PLANNING CONSULTATION RESPONSE

Application No	2026/0402
Proposal	Conversion of existing attached garage to ensuite bedroom and first floor side extension above
Address	27 Chapel Street, Birdwell, Barnsley, S70 5UW
Date of Consultation Reply	20 th August 2026
Consultee	Highways DC

Consultation Assessment and Justification

Site plan

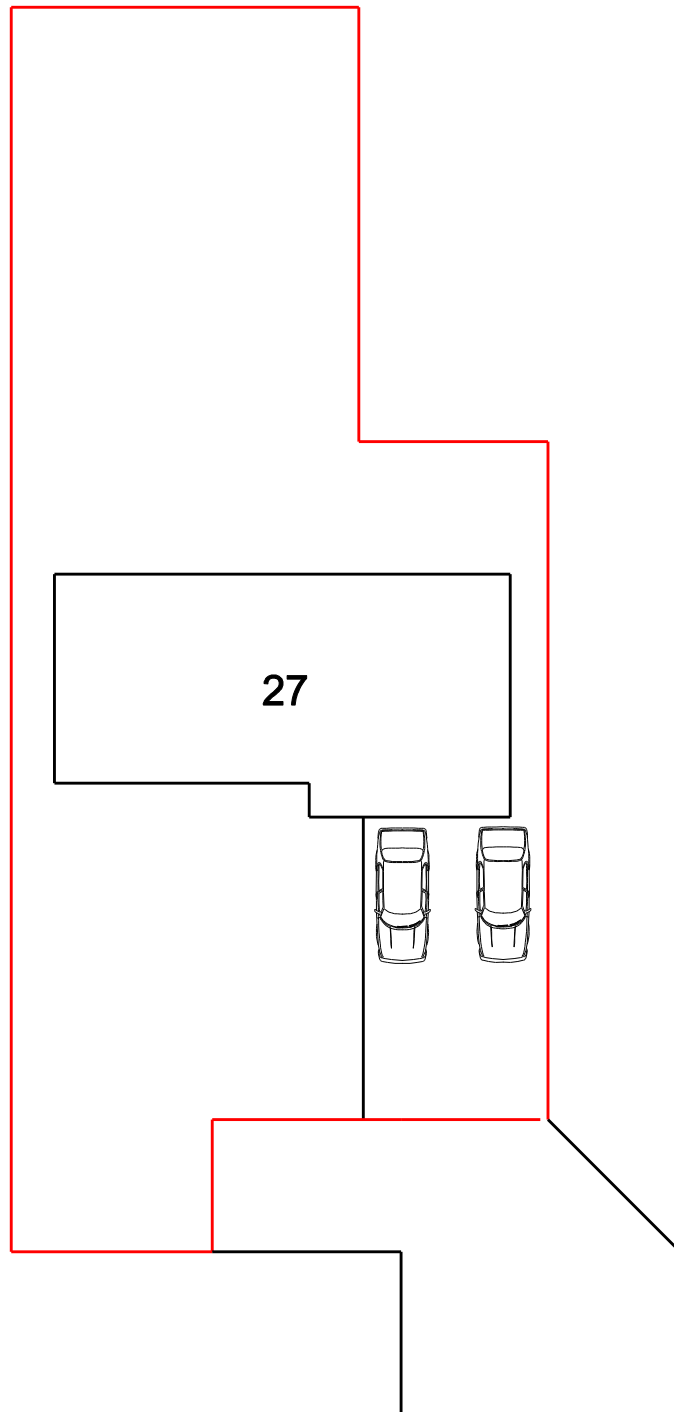
The proposed alterations and extension to the dwelling result in the loss of the attached garage as an off-street parking space. However, it is proposed to create a replacement parking space on the property frontage alongside the existing driveway. In accordance with the Barnsley Supplementary Planning Document (SPD) Parking (2019) Table 1, for dwellings with three or more bedrooms, two off-street parking spaces are required with each space having minimum dimensions of 5m x 2.5m. The level of parking provision is therefore sufficient.

However, due to the increased width of the driveway, it is doubtful that the remaining turning area would be of sufficient size to allow both spaces to be adequately accessed/egressed. It is therefore suggested that the layout is amended along the lines of the sketch below:

As can be seen, the turning area should be extended, and a bin store should be incorporated into the layout.
